DEPARTMENT OF PUBLIC WORKS

MEMORANDUM

SUBJECT: Starview Short Plat SP-08-00039

STAR VIEW SHORT PLAT

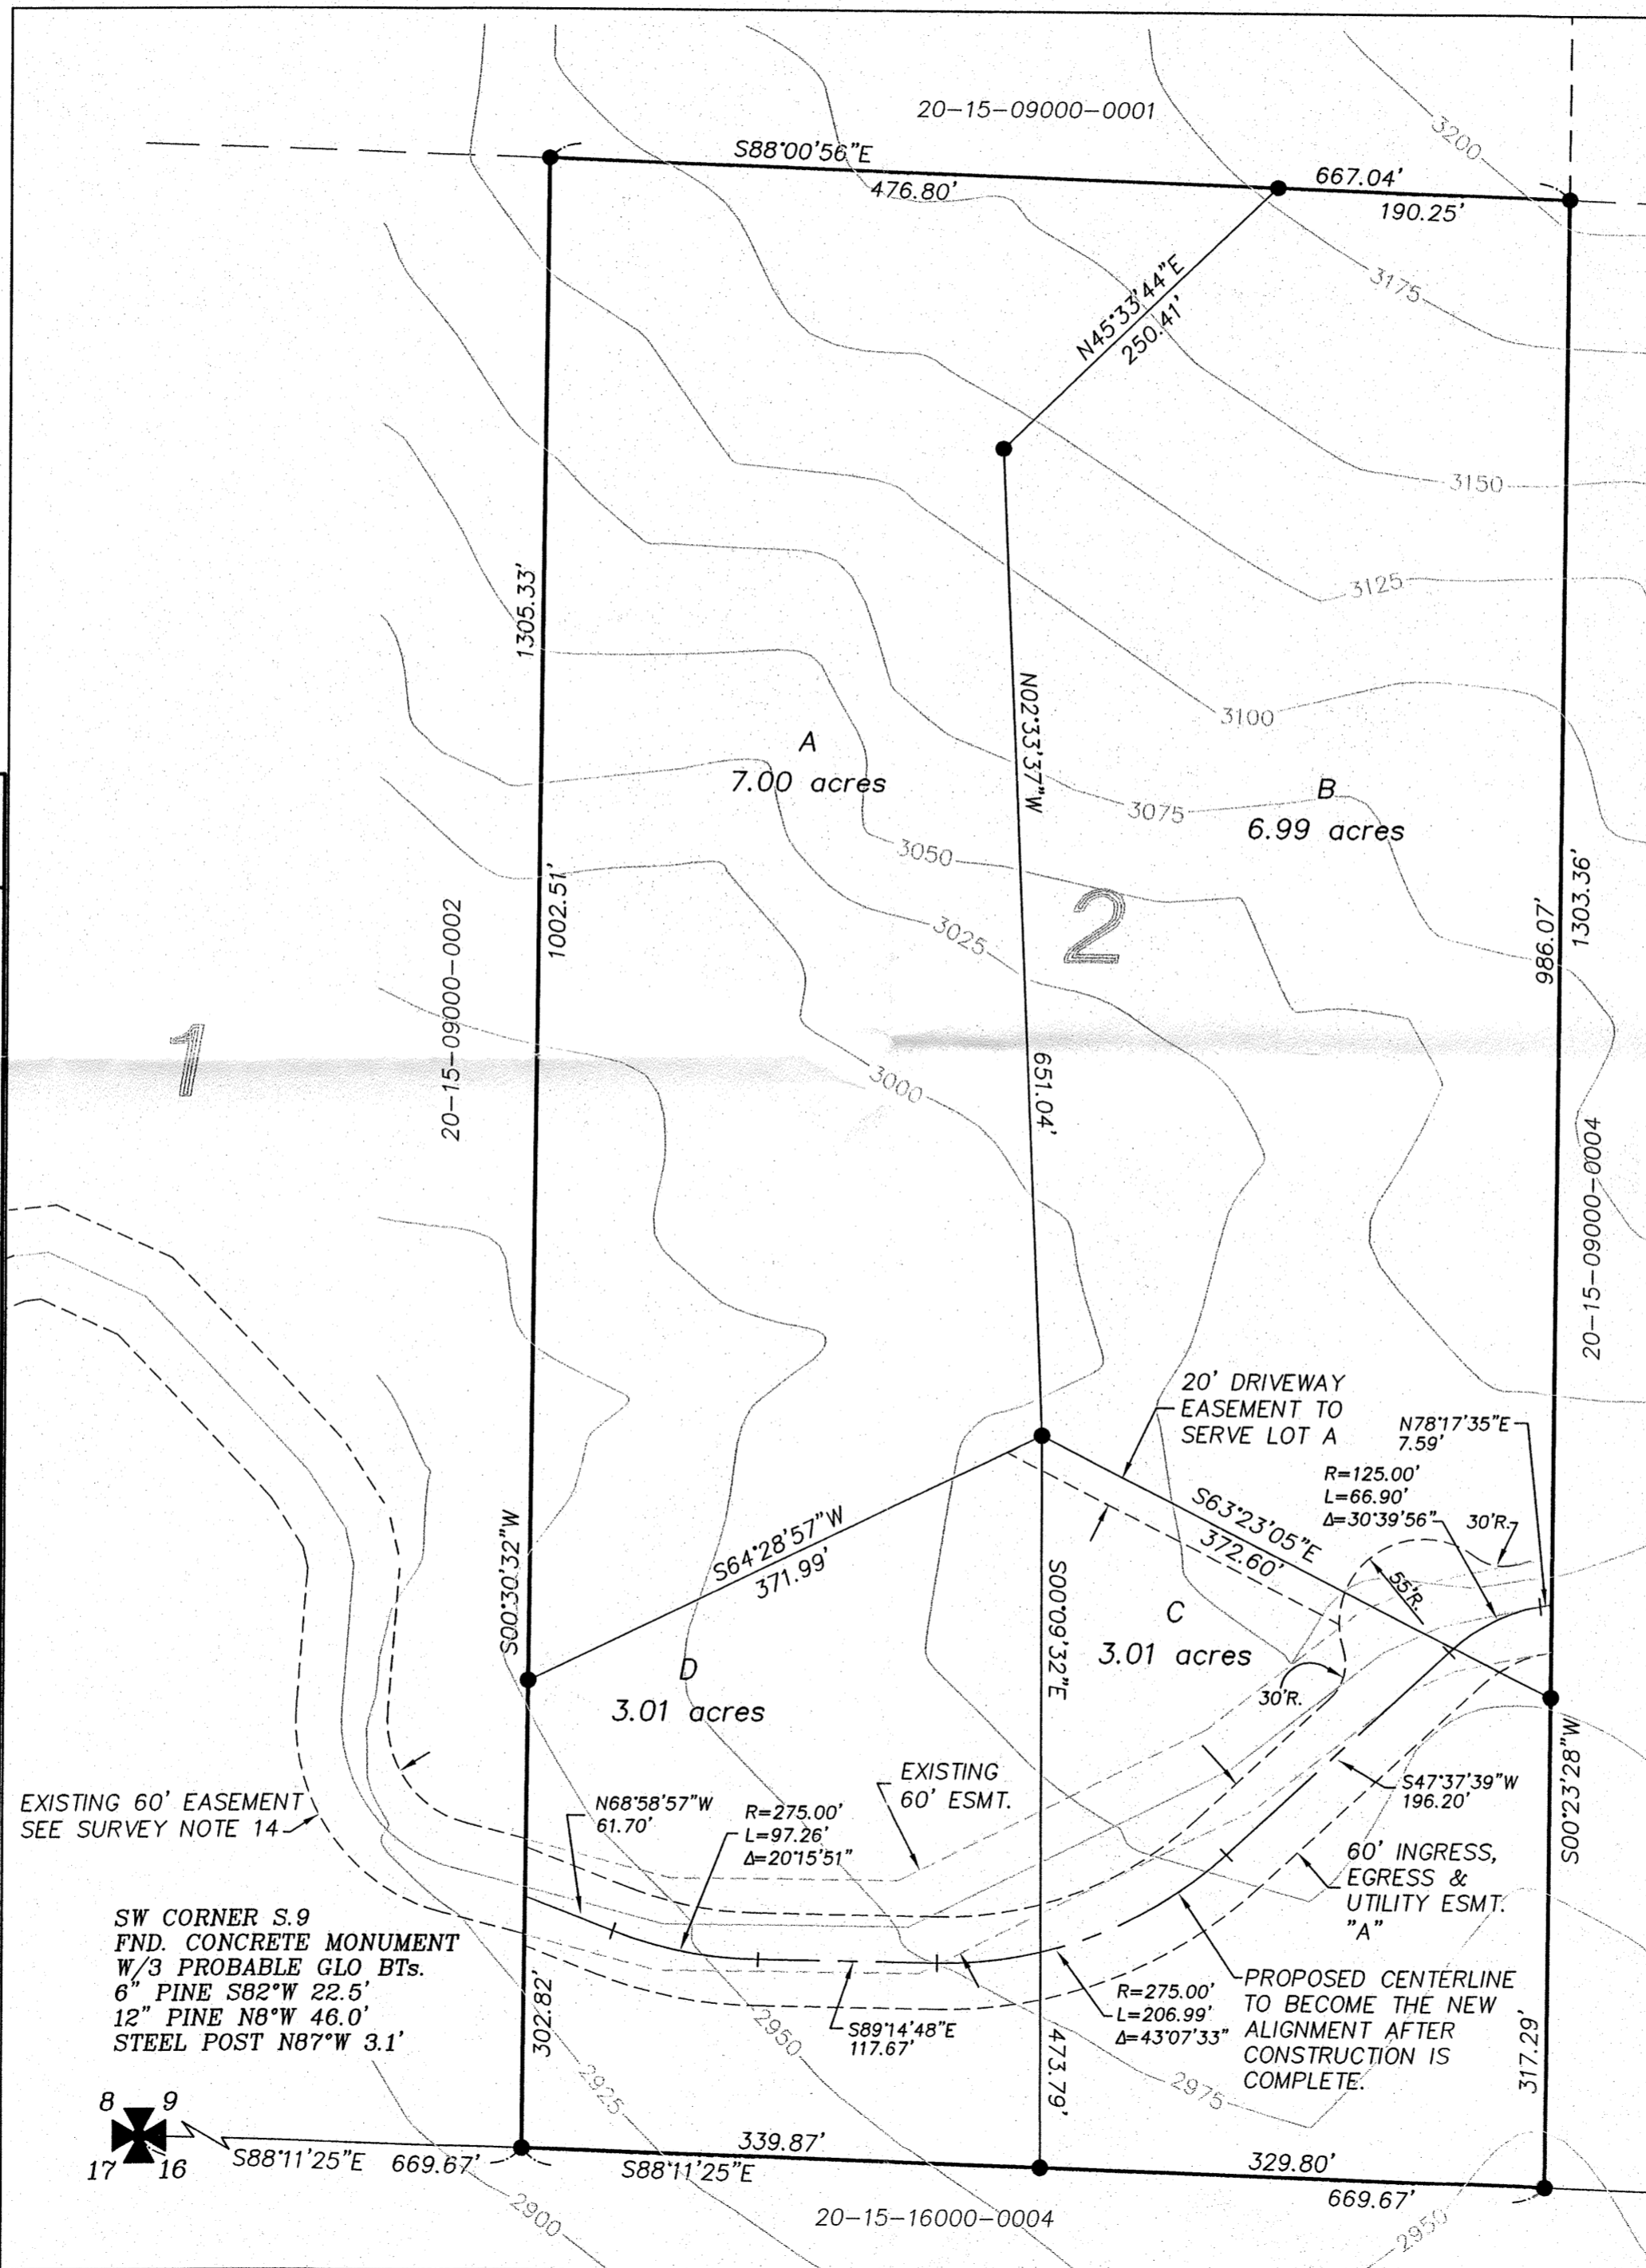
3. Road Variance: The applicant applied for and received a variance for grade and road width. The following conditions of RV-10-05 are required:
 - a. Applicant must mitigate with design all current 18% road grades to less than 15%; include turnouts every 600' for the entire length of the road to allow for 18' road width in lieu of the 22' standard.

- b. Cul-de-sac location must be addressed either by easement or placed on landowner's property.
 - c. Address fuel reduction concerns during design along all roadside areas.

- a. Access easements shall be a minimum of 60' wide. The roadway shall have a minimum width of 20', with 1' shoulders, for a total width of 22'.
 - b. Minimum centerline radius will be 60'.

- c. The surface requirement is for a minimum gravel surface depth of 6".
 - d. Maximum grade is 12%.
 - e. Stopping site distance, reference AASHTO.

5. Cul-de-Sac: A cul-de-sac turn-around having an outside right-of-way or easement diameter of at least 110 feet shall be constructed at the closed end of all dead-end roads serving 3 or more lots. The driving surface shall be at least 96 feet in diameter. Cul-de-sacs must also conform to the requirements specified by the 2006 International Fire Code. Contact the Fire Marshal regarding any additional cul-de-sac requirements.
